Name	Company	Email
To	Michael Azar	Ecove	michael@ecove.com.au
	Charmaine Pang	Bates Smart	cpang@batesmart.com
	Andrew Brohier	McKenzie Group Consulting	abrohier@mckenzie-group.com.au
Date	04/04/2016	Job no SY150512	Version CA1.4
Project	Site 9 – Sydney Olympic Park

We have prepared this advice to identify and document the fire safety measures that are likely to be required for the proposed residential tower development at Site 9, Sydney Olympic Park to achieve compliance with the performance requirements of the National Construction Code Series 2015 Volume One – Building Code of Australia (BCA)¹. This review is based on the documentation listed in Appendix A.

**General Arrangement Plan  
Ground**

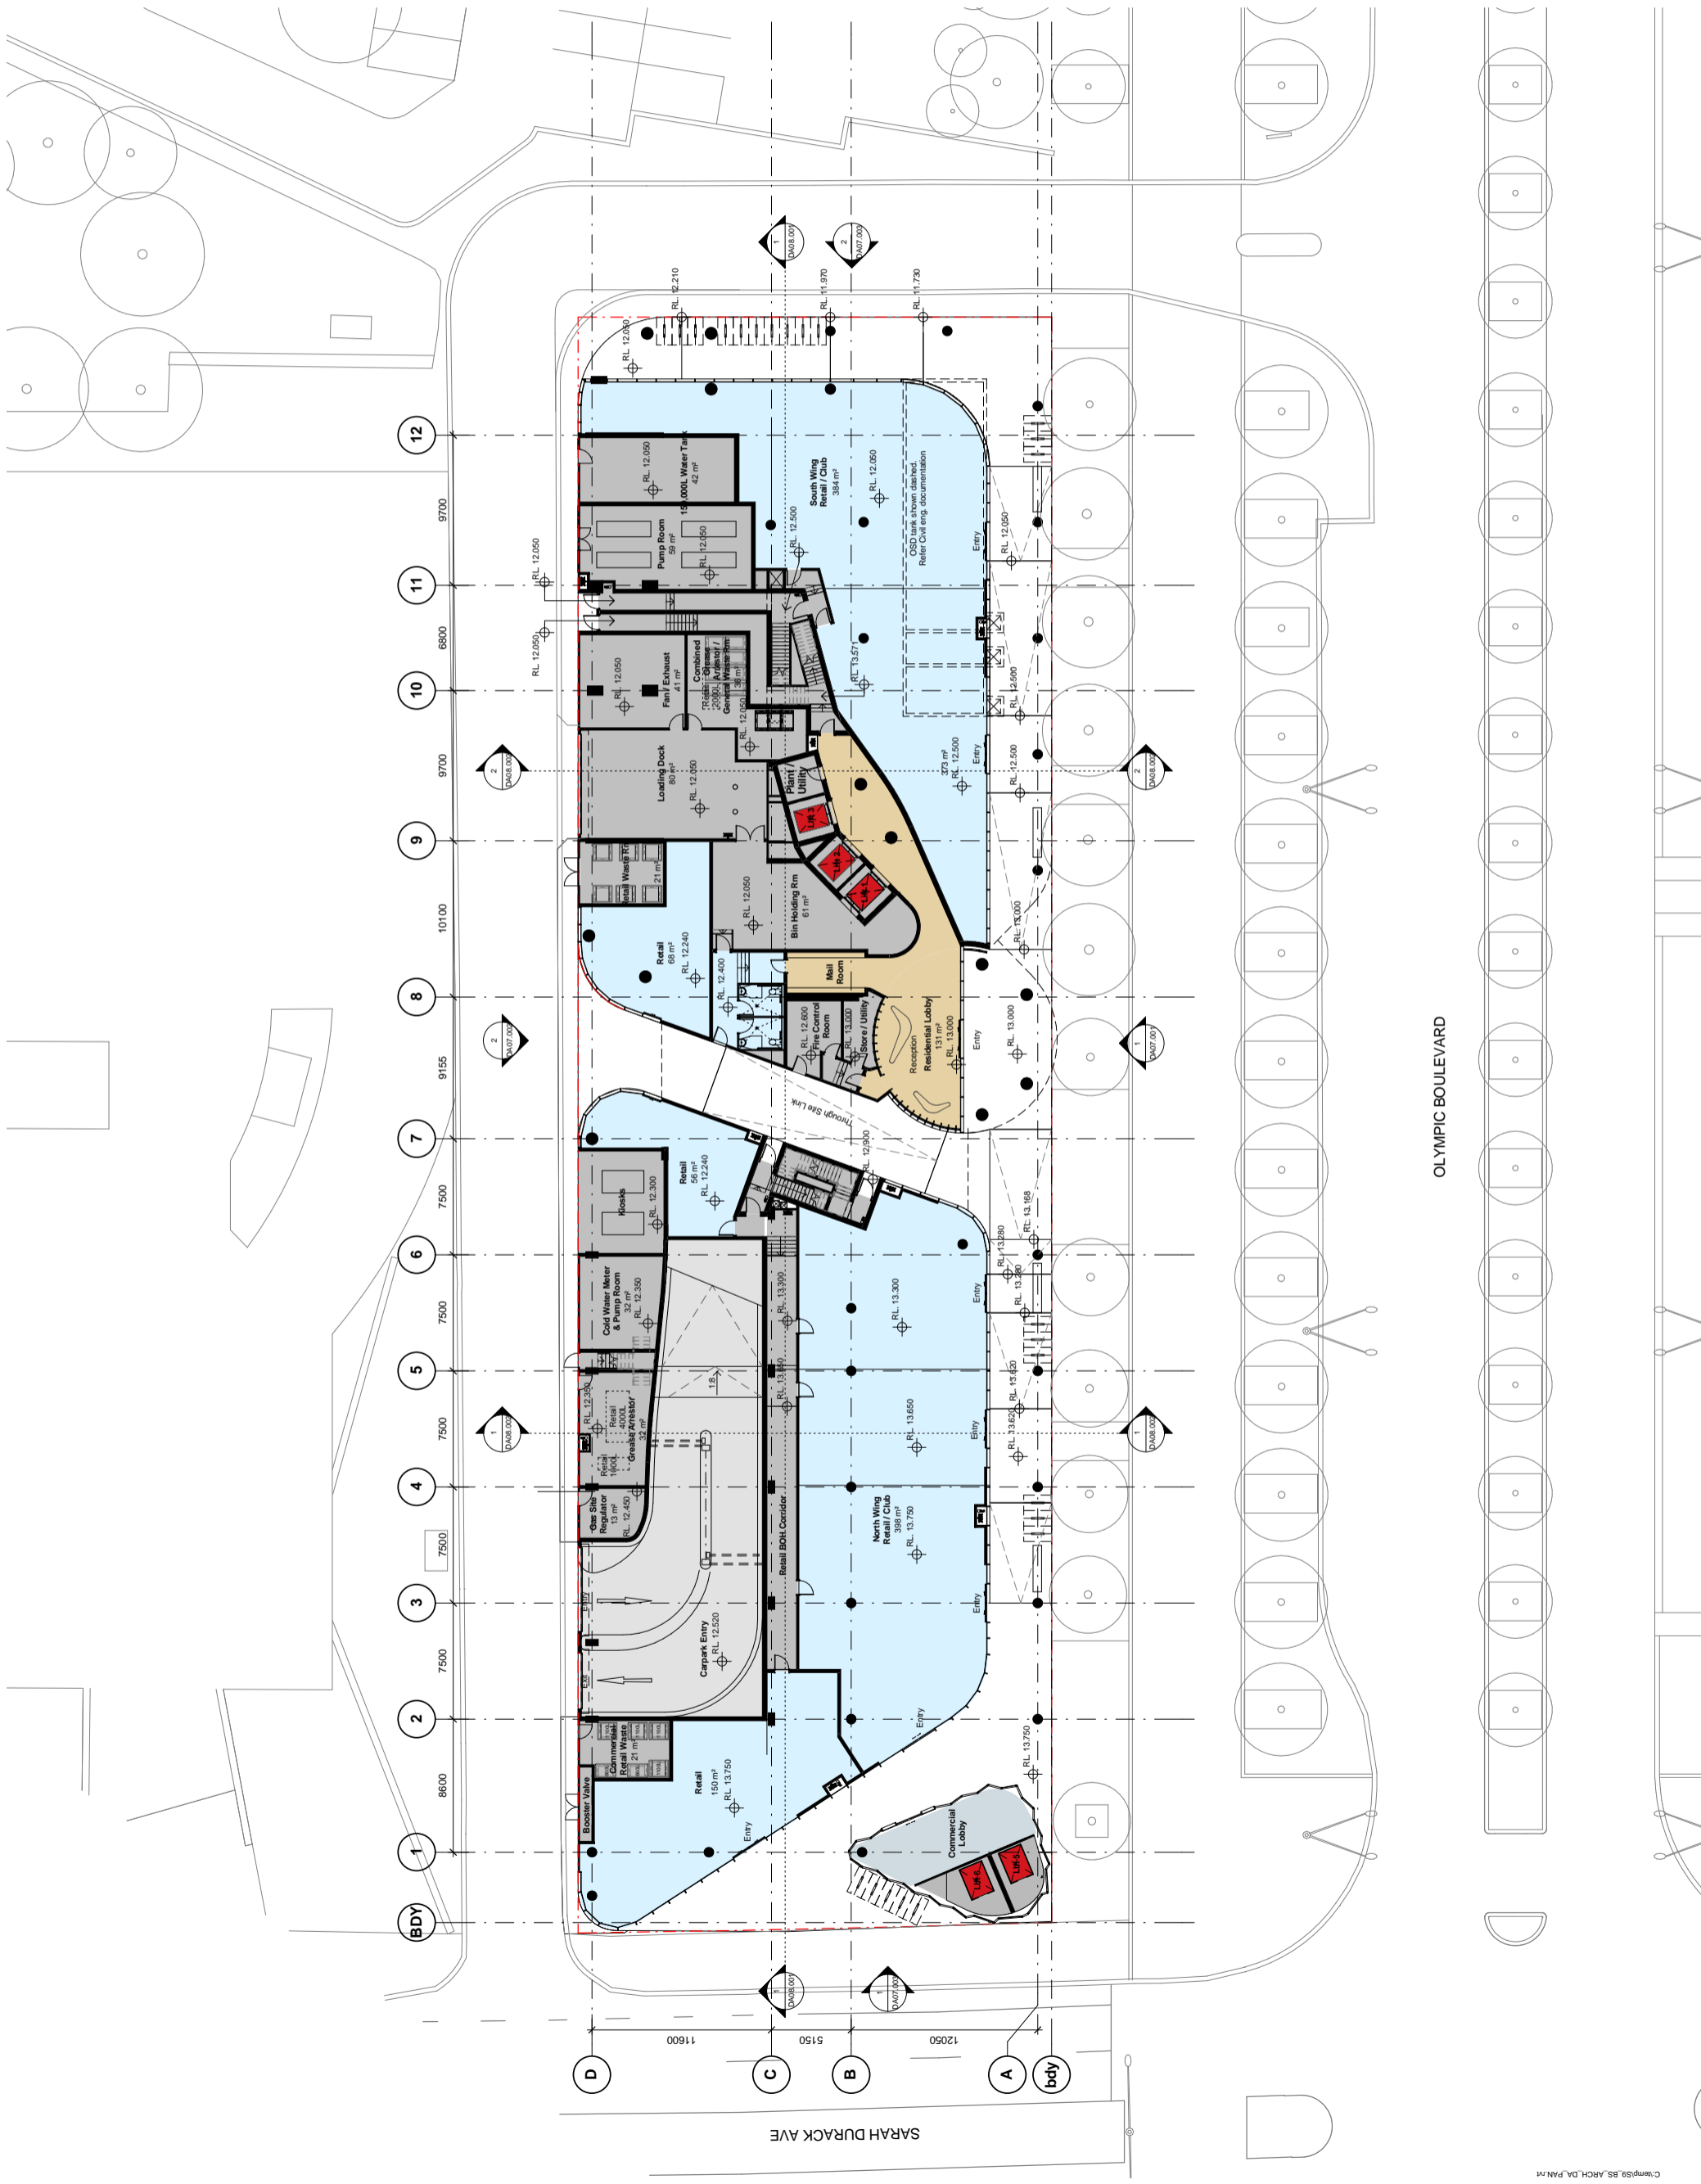
4. The retail areas on the ground floor must be separated from the other classifications on the storey by a fire wall and floor above that achieve an FRL of not less than 120/120/120 instead of 180/180/180 as required by clauses C2.7, C2.8 and C2.9 of the BCA. Refer to Figure 1.

18. The proposed location of the fire hydrant booster assembly adjacent to the carpark entry as shown in Figure 1 is not considered comply with AS 2419.1-2005 as it is not within sight of the main entry to the building being the main residential entry lobby.
Note: The proposed location of the fire hydrant booster will need to be referred to FRNSW for approval.

19. The building is required to be provided with a fire control room in accordance with clause E1.8 of the BCA. The fire control room is proposed to be accessed via the through site link and the residential entry lobby as shown in Figure 7.
Note: The proposed location and access to the fire control room will need to be referred to FRNSW for approval.

General Arrangement Plan  
 Level 03

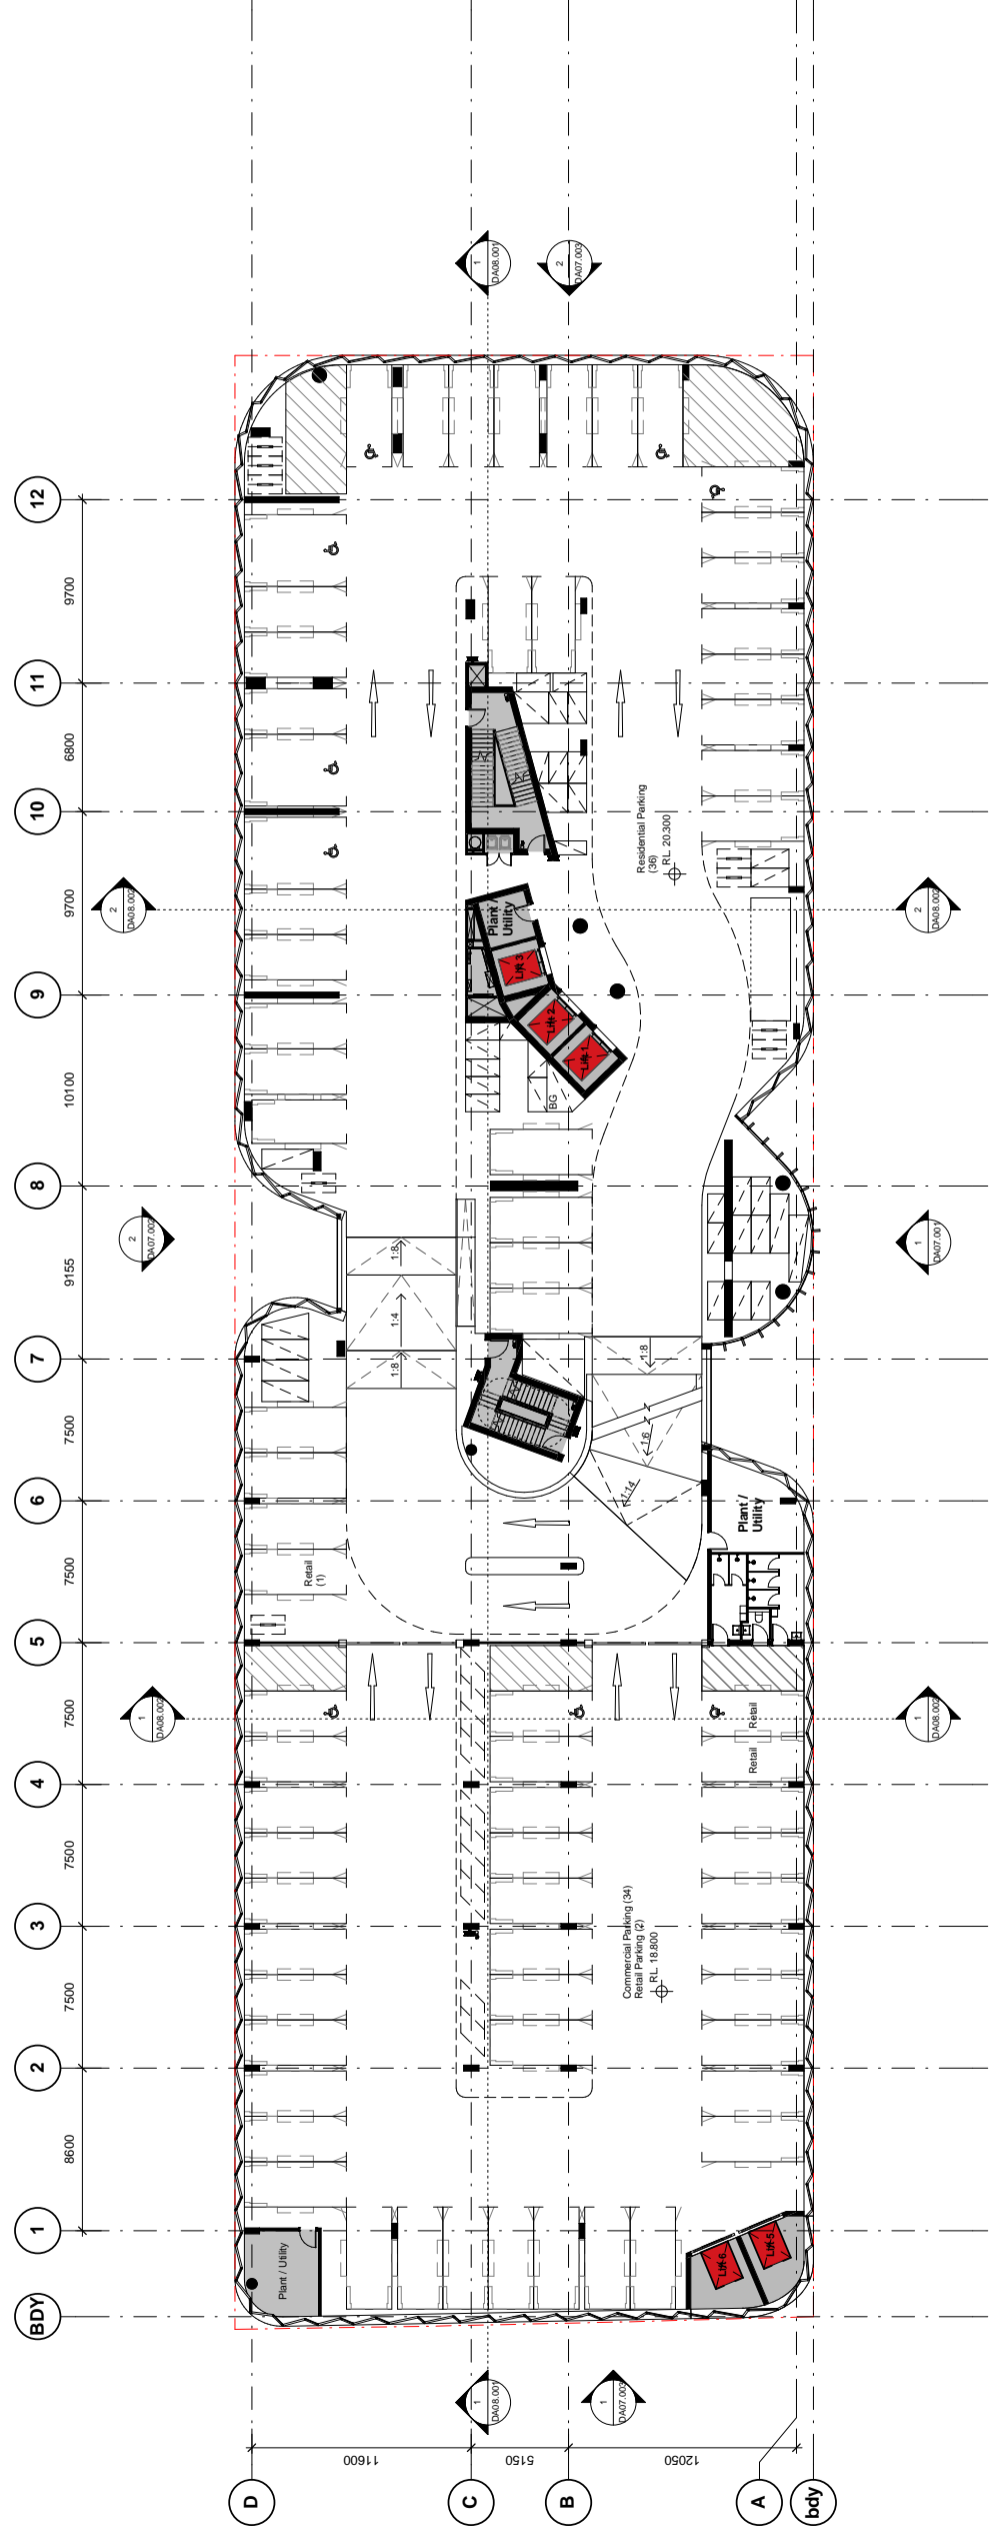
8. The following maximum travel distances apply within the podium carpark levels of the building:
- a. 20m to a single exit or point of choice
 - b. 55m to the closest of two or more alternative exits
 - c. 60m between alternative exits.

**General Arrangement Plan  
Level 07**

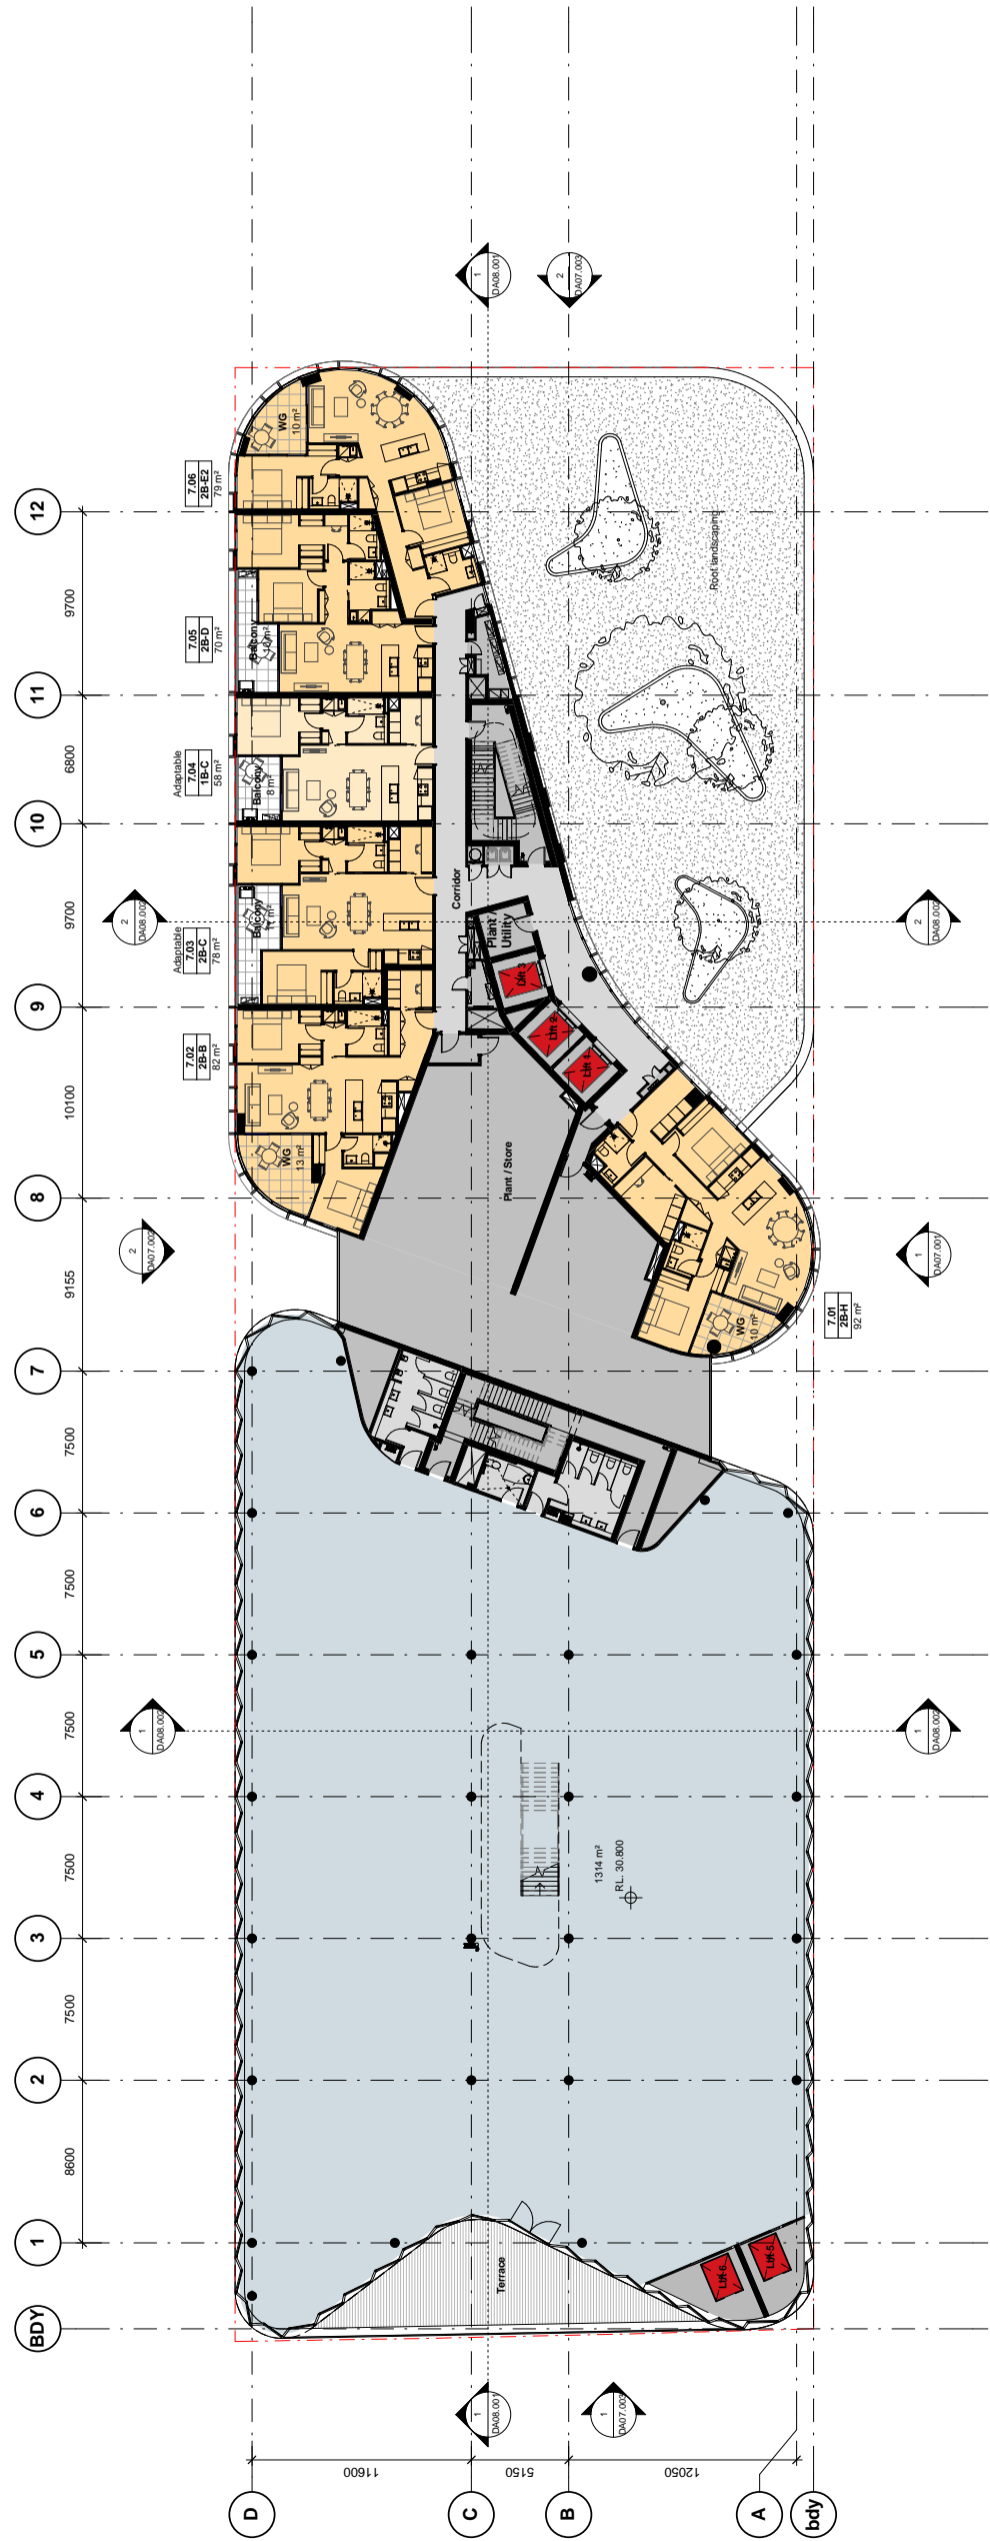
9. The following maximum travel distances apply within the commercial office levels of the building:
- 20m to a single exit or point of choice
 - 50m to the closest of two or more alternative exits including fitout
 - 60m between alternative exits.

11. The maximum travel distance to a point of choice/nearest exit from the plant areas on levels 7 and 8 may be extended to 27m in lieu of 20m.
12. The maximum travel distance to a point of choice/nearest exit from the common area/room on level 9 may be extended to 30m in lieu of 20m.
